PLANNING AMENDMENT

Application No. H01/1174/96
Date Registered 11 FEB 1997
Case Officer pu

Proposed House & Garage

Amendment: Plot width widened to 15.5 metres.

## BLOCK PLAN

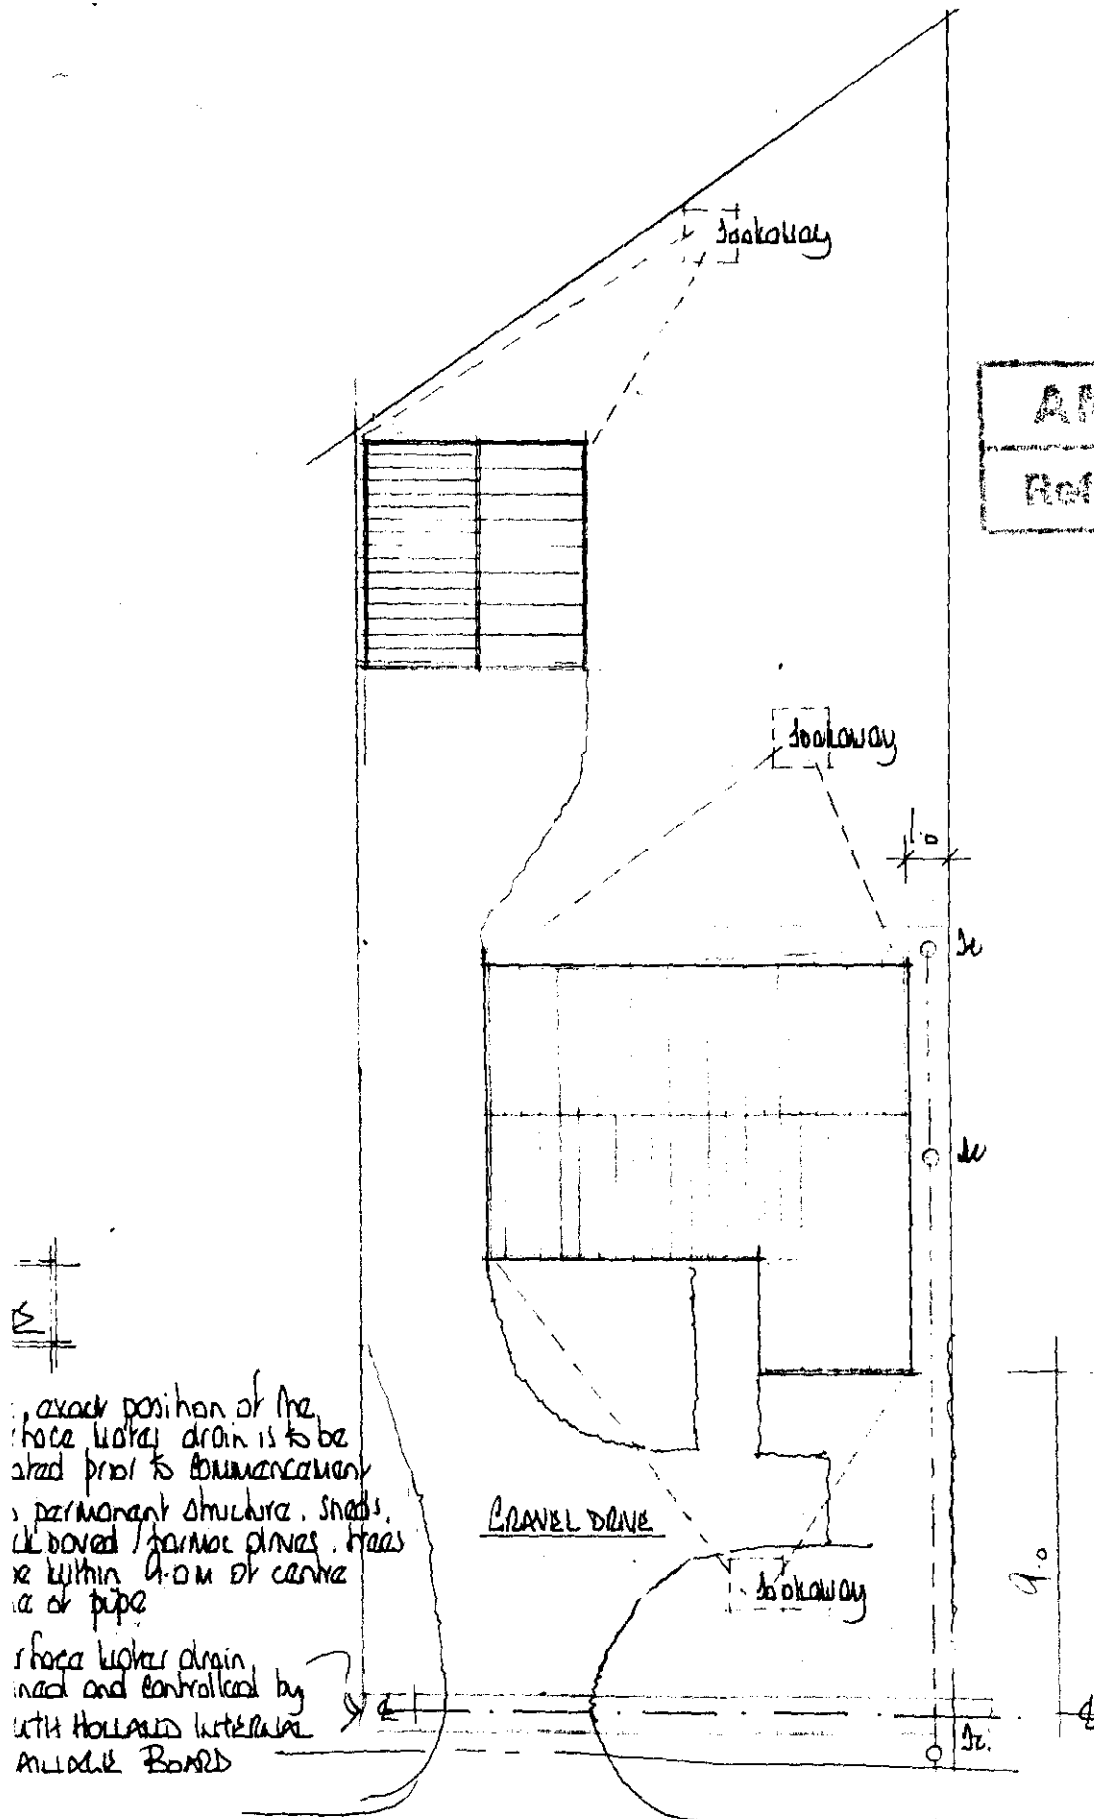
Plot width widened to 15.5m.

Revised Block Plan
